From: Michael Barker [REDACTED]
Sent: 18 April 2017 10:48
To: David Easton
Subject: RE: A/45/17/CLP - 15 The Walkway, Angmering

From: David Easton [REDACTED]
Sent: 12 April 2017 16:50
To: [REDACTED]
Subject: A/45/17/CLP - 15 The Walkway, Angmering

Having looked at the certificate of lawfulness application which has been submitted under reference A/45/17/CLP it appears that the proposed railings would not accord with the limitations of Schedule 2, Part 2, Class A of The Town and Country Planning (General Permitted Development) Order 2015 (as amended) as they would be situated adjacent to the highway and exceed 1m in height.

PROPOSED GROUND FLOOR CLIENT OPTION

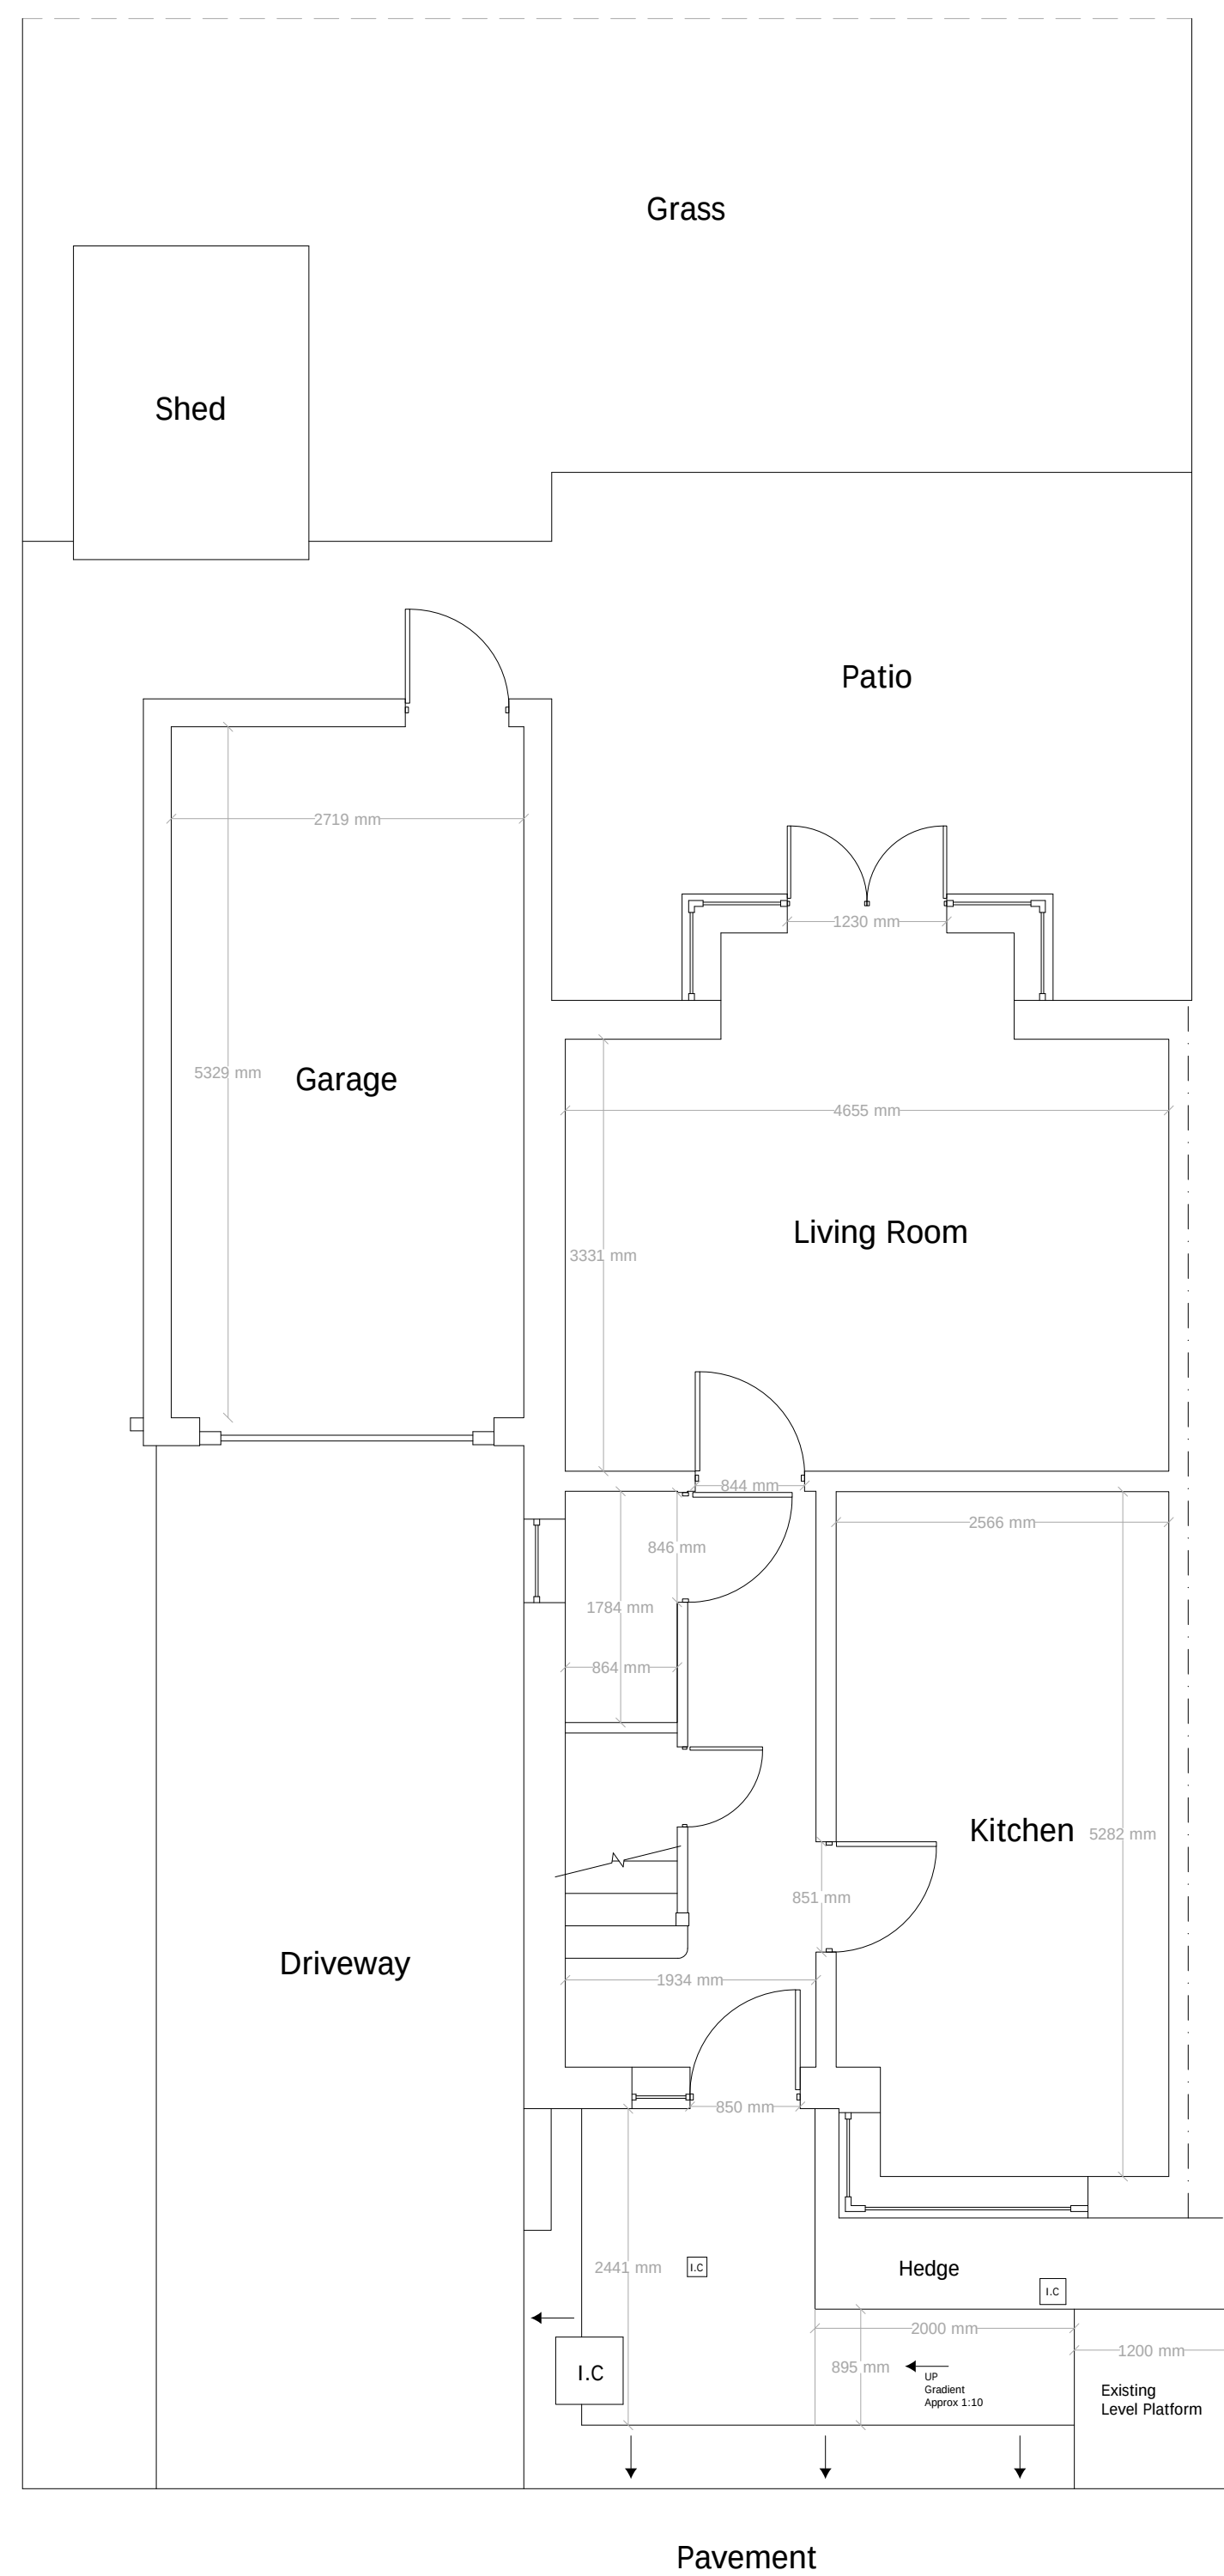
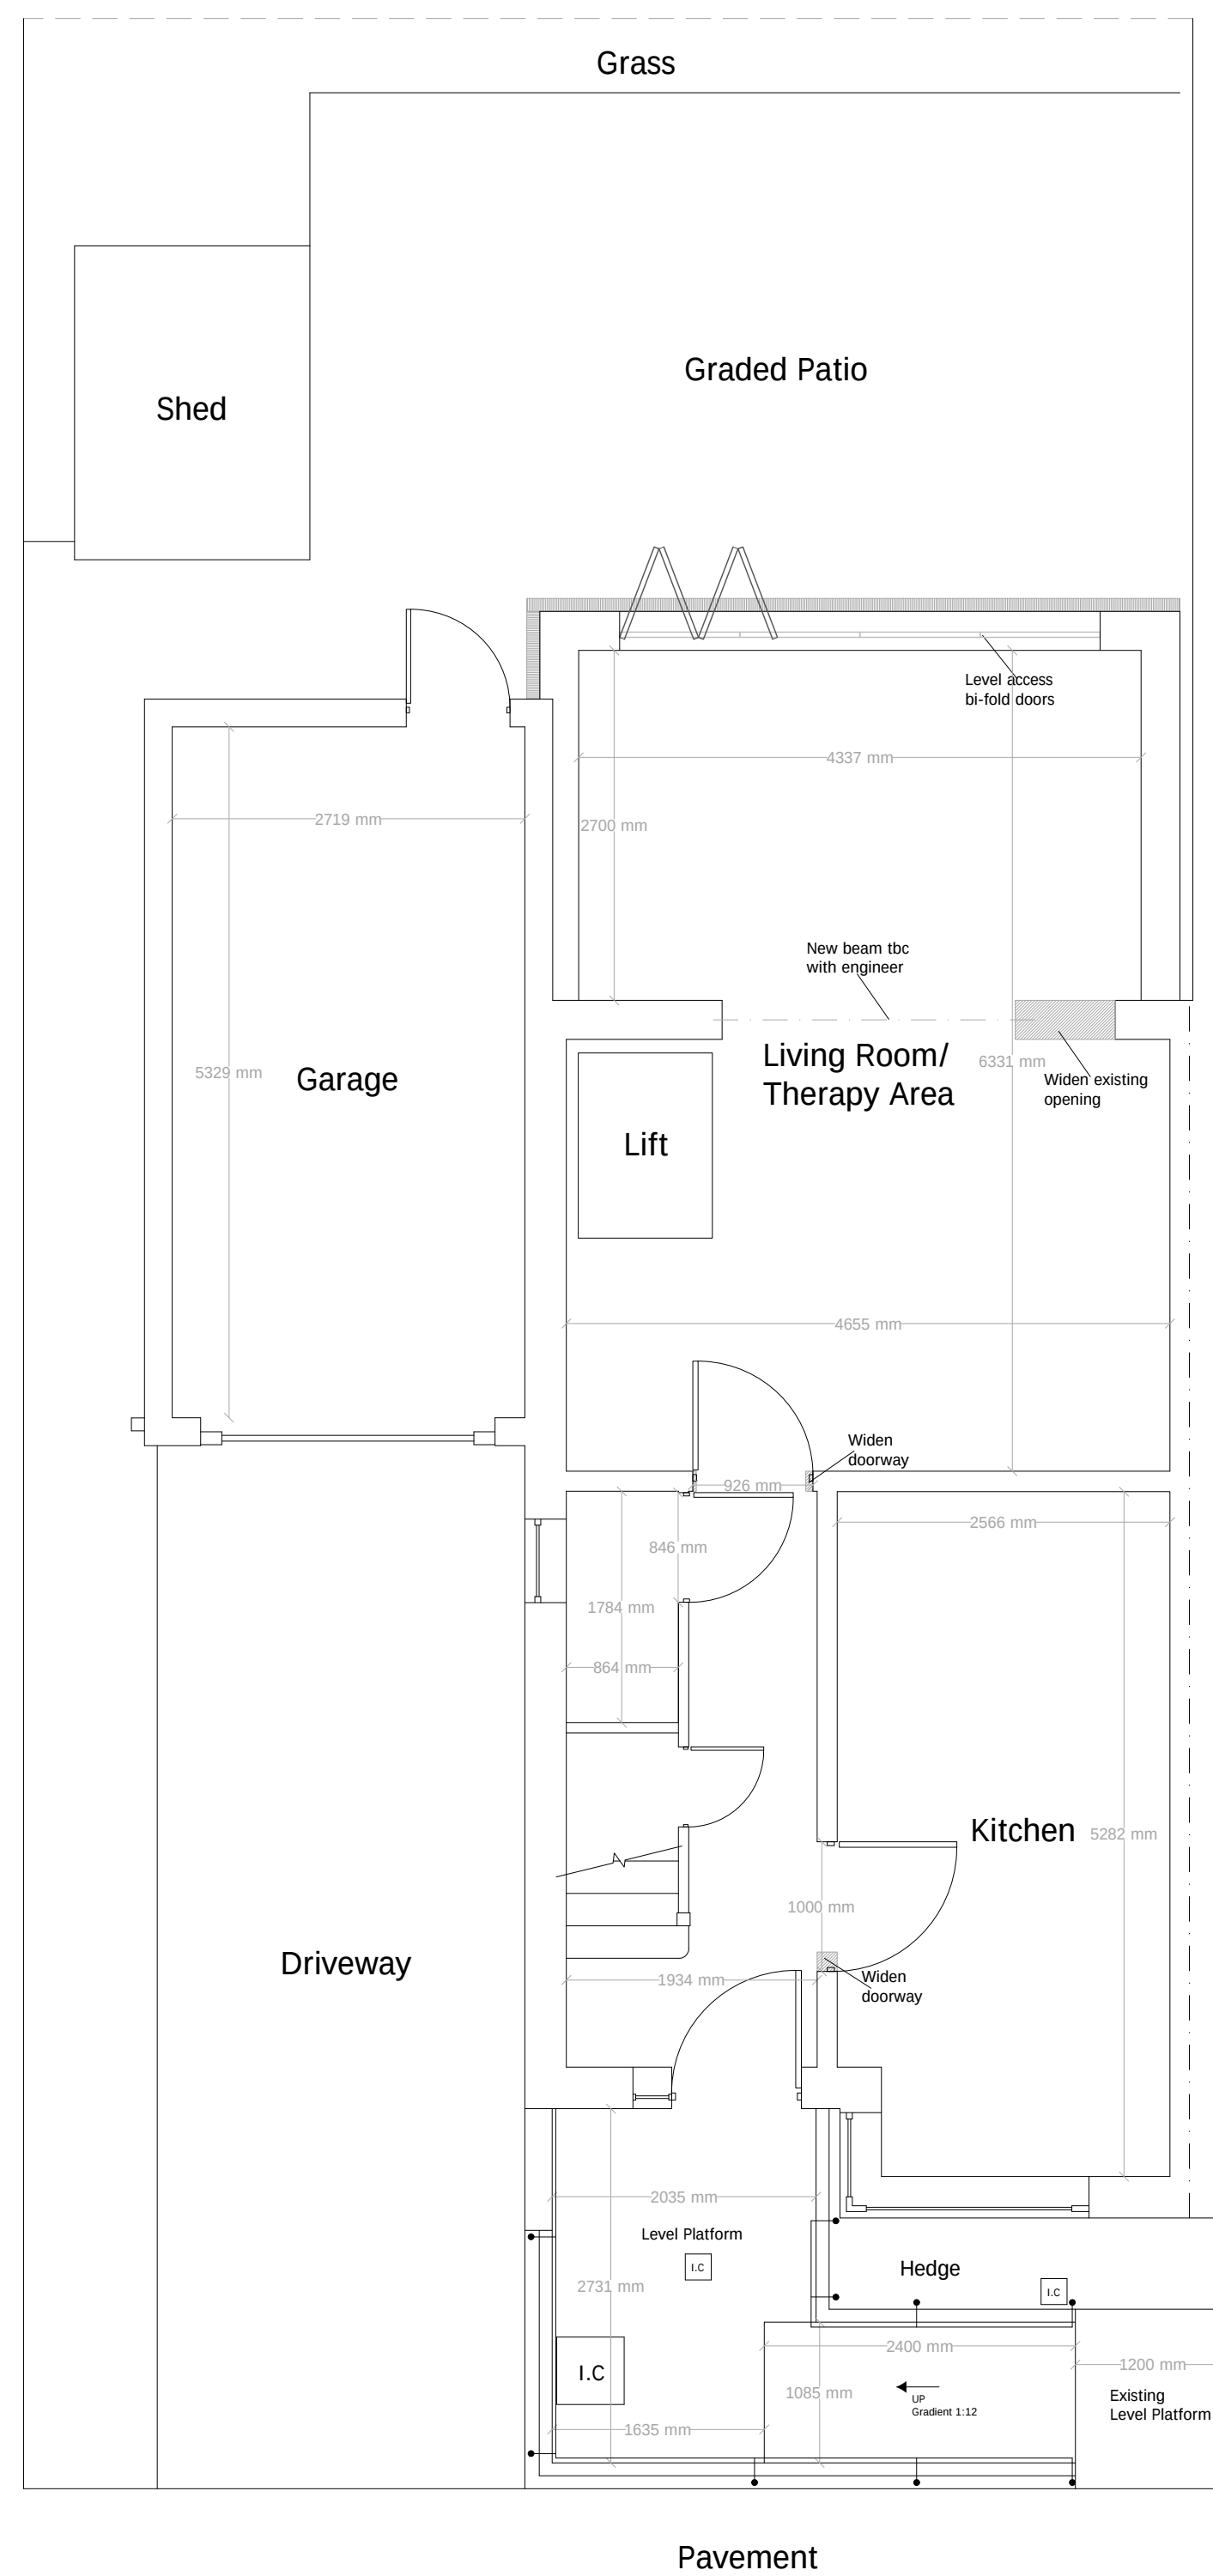
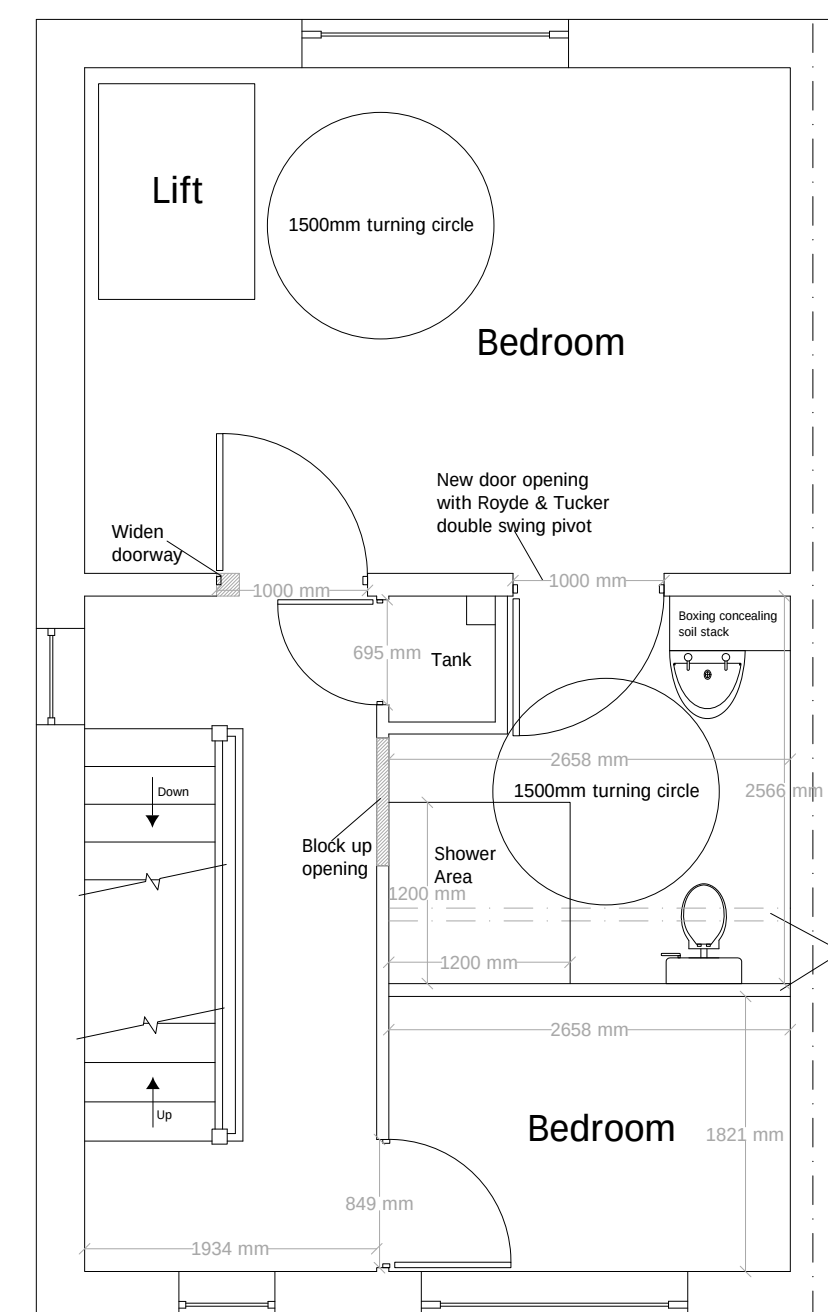
It should also be highlighted that the new access ramp shown forward of the primary elevation by virtue of its location and attachment to the dwelling house would not benefit from permitted development rights under Schedule 2, Part 1, Class A of The Town and Country Planning (General Permitted Development) Order 2015 (as amended). Thus the railings must be reduced in height and the access ramp will need to be removed from the application in order for the certificate of lawfulness to be granted. Failure to amend the application as set out above will prevent the lawful development certificate from being granted.

Please find attached the amended plans as requested. I have omitted the front access from this application and submitted a separate planning application for the front access only. Please also note that the roof construction has changed to a flat roof.
